Re. A1 in Northumberland : Morpeth to Ellingham, Scheme No. TR010059

The changes proposed to the river crossing outlined in the “Summary of Proposed Changes to Application” recently submitted by Highways England have potential to adversely affect our interests and I would like to register our concerns.

Permanent Works at the River Coquet

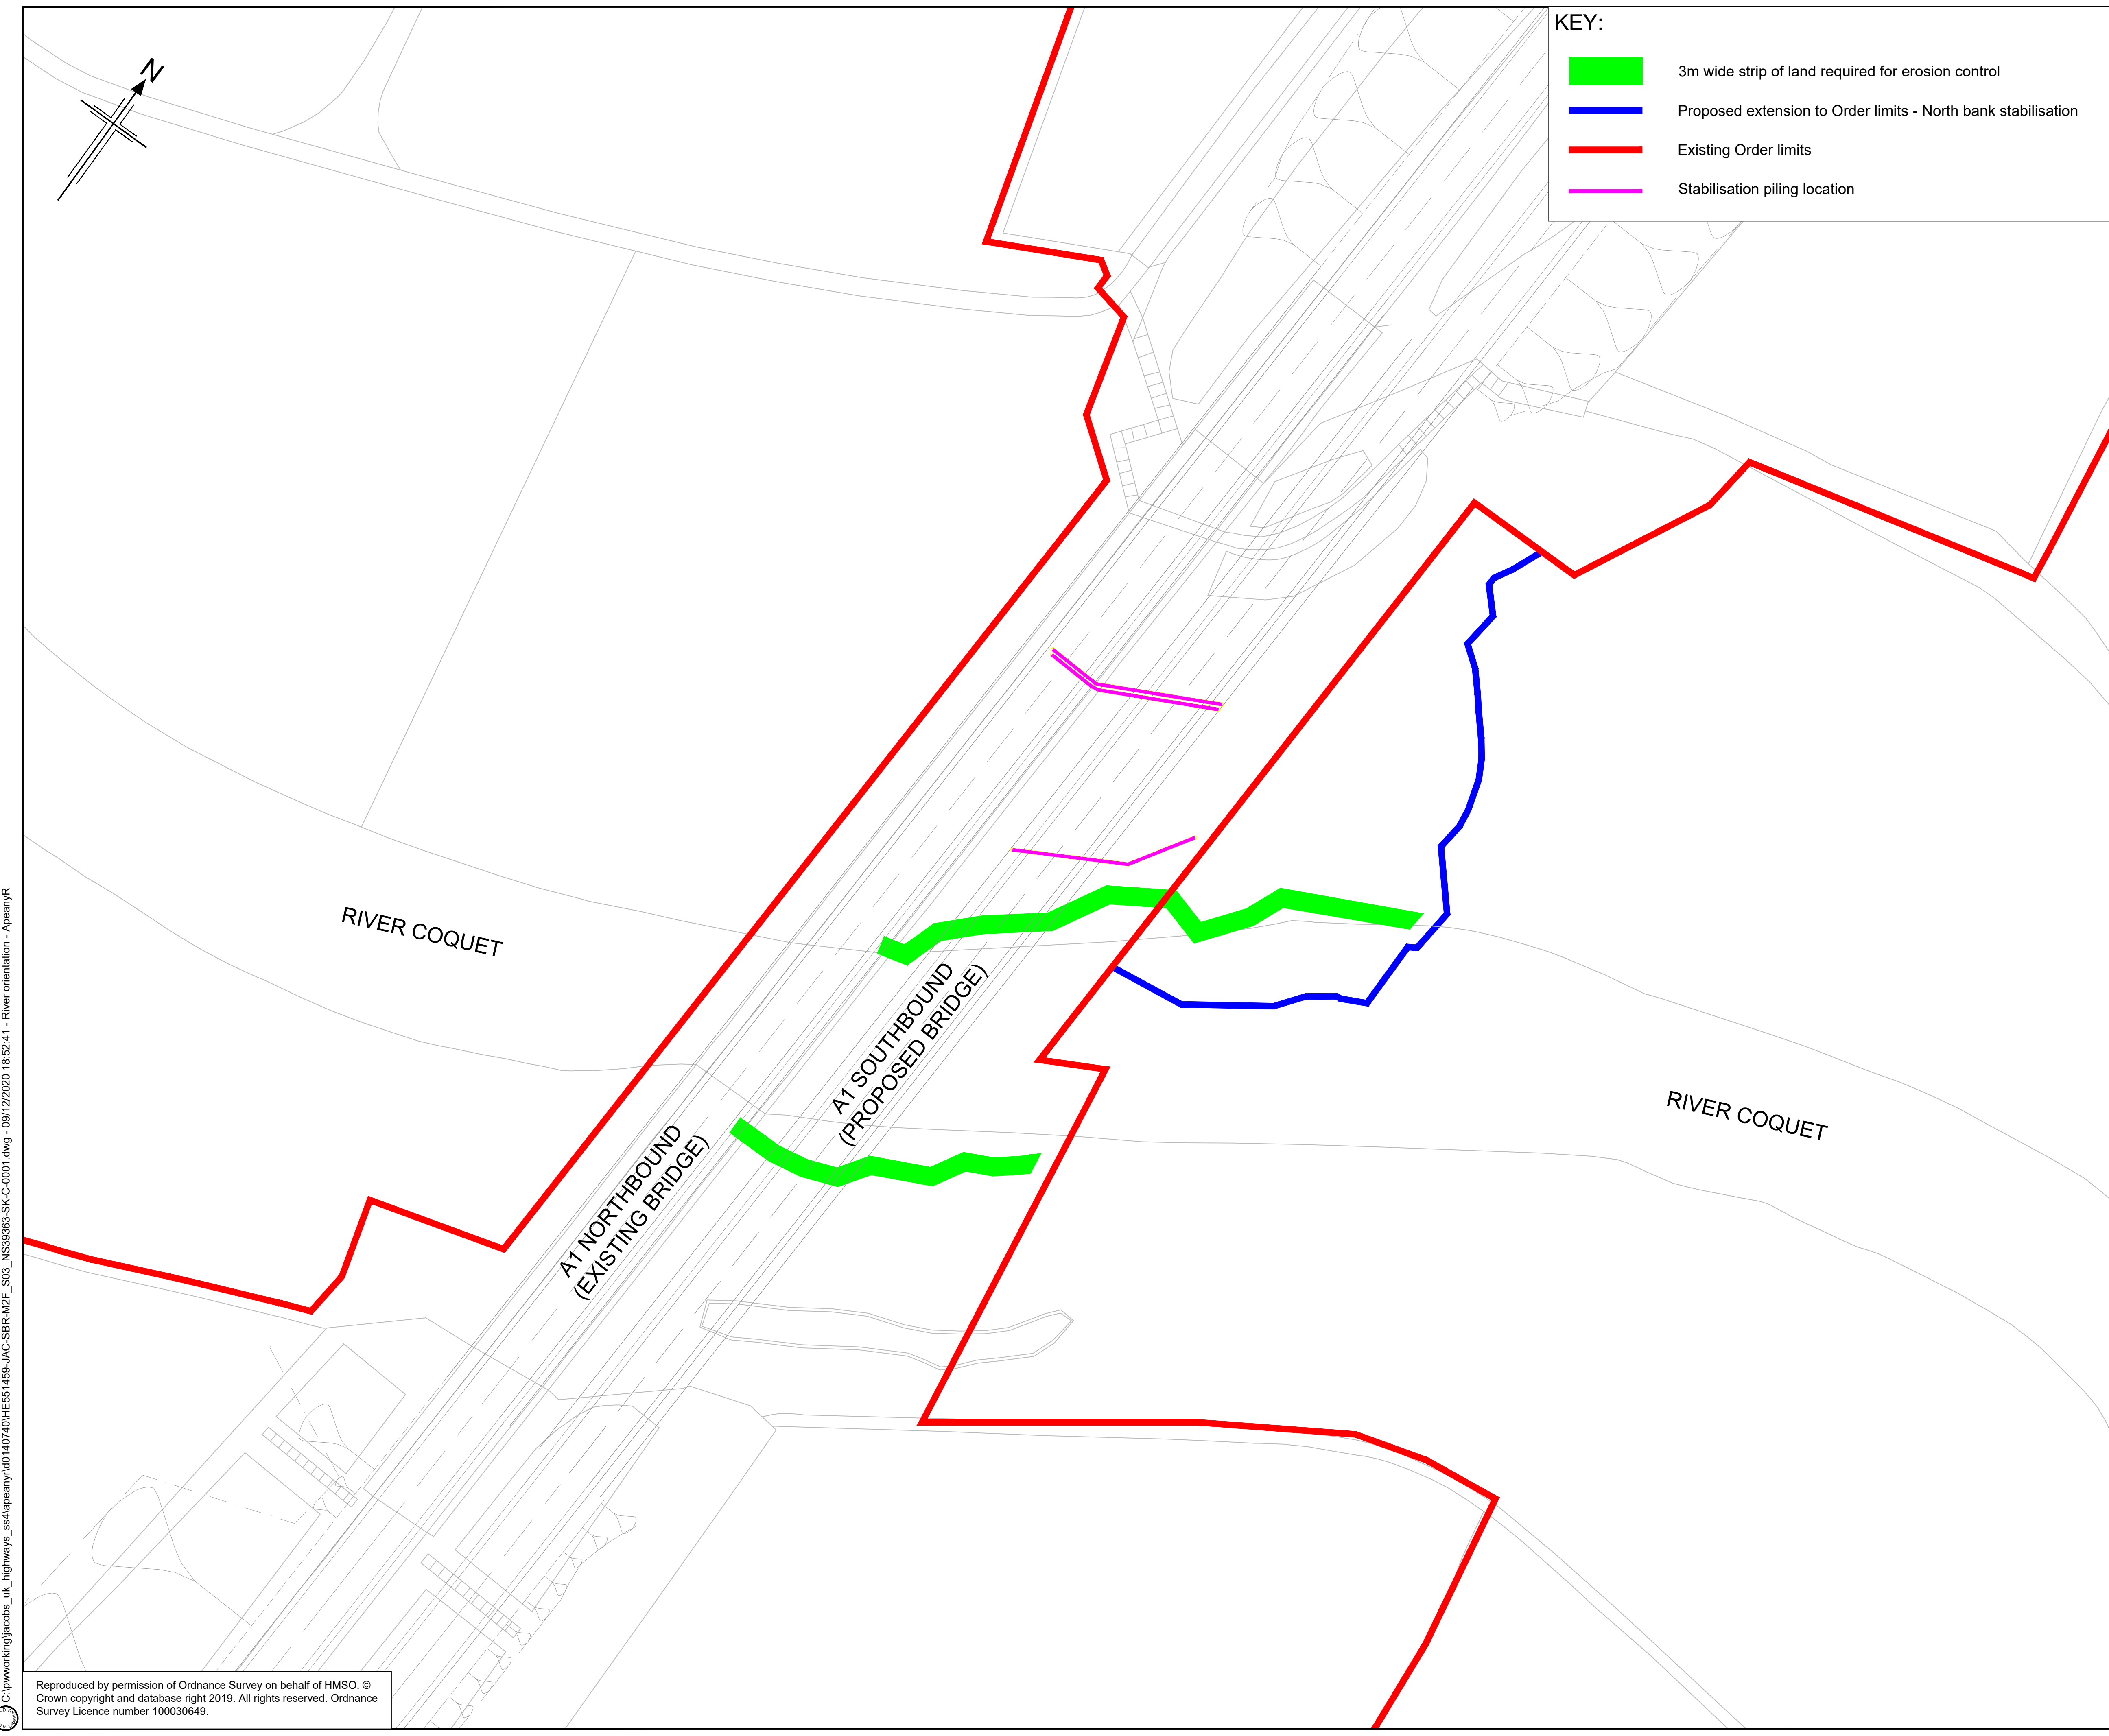
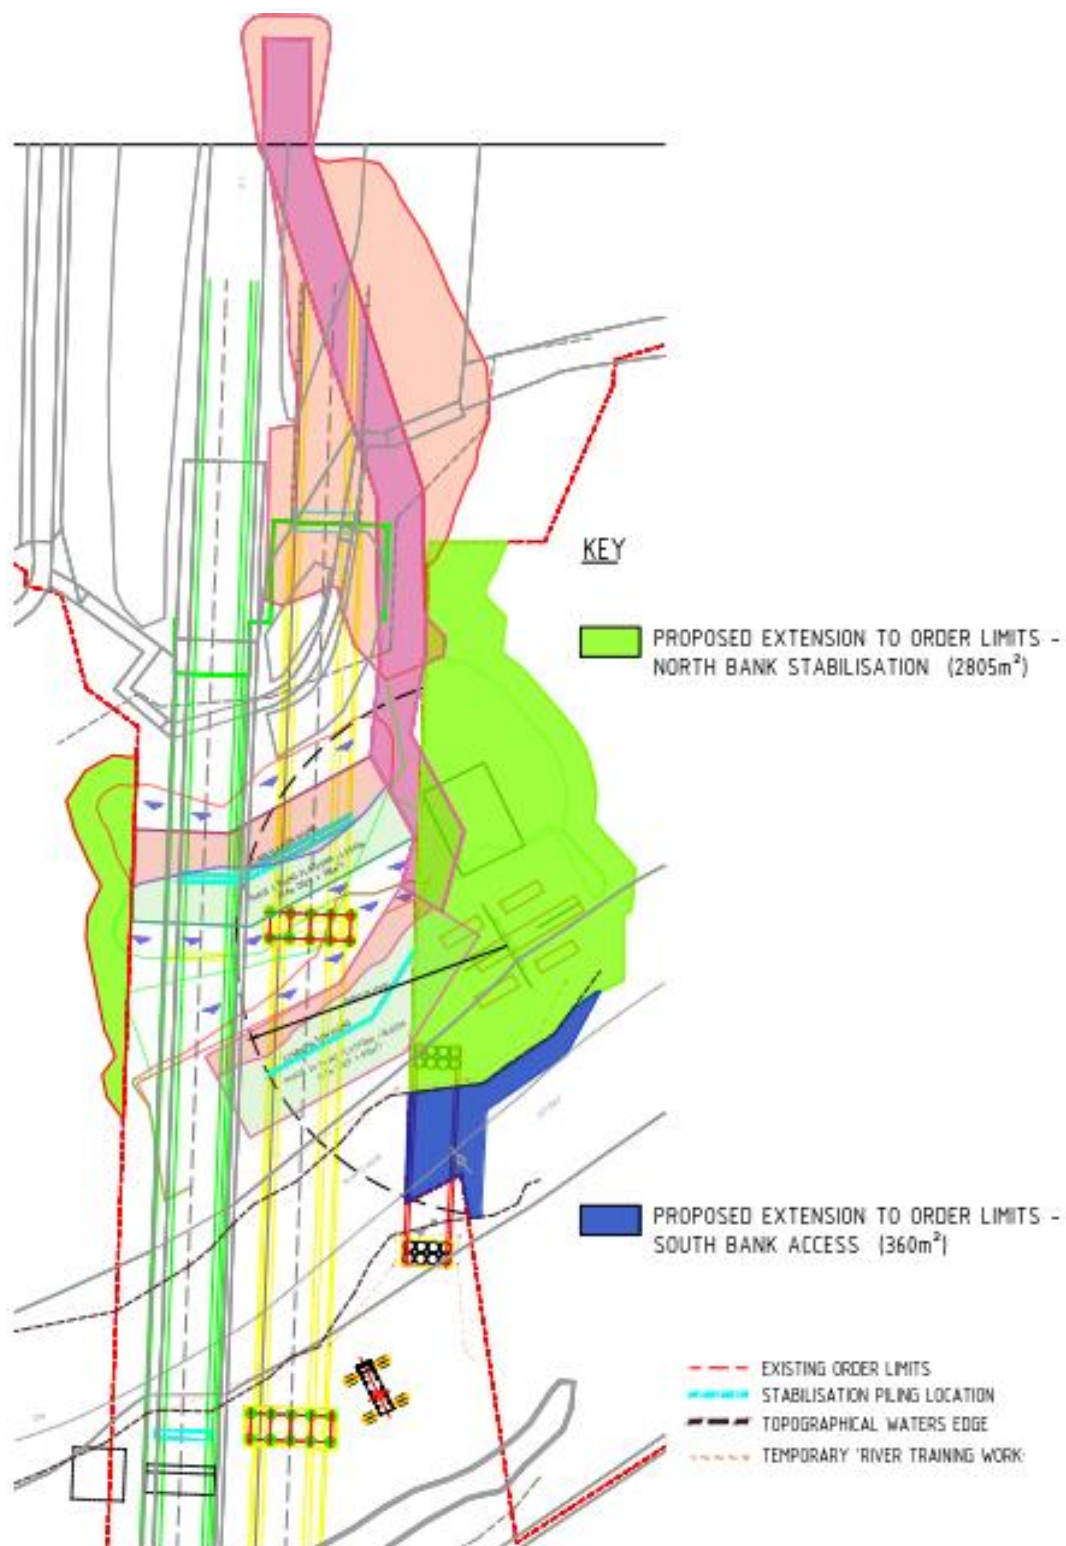
The proposed bank stabilisation works are on land owned by others but one of our access routes descends to the river underneath the existing A1 viaduct and crosses the area in which piling is proposed. We would like assurance that traversing this area will be possible once the piling is complete and to know whether it will be possible during the works.

The armouring of the banks proposed has potential to affect the river’s hydraulic characteristics, particularly in higher flows, and we would like assurance that this will not affect fish passage.

Similarly, while a temporary bridge is probably an acceptable means of accessing the work area on the south bank, poor design of this and its construction and removal may also adversely affect fish passage. There is insufficient detail in the “Proposed Changes” to satisfy us that the work will be done without detriment.
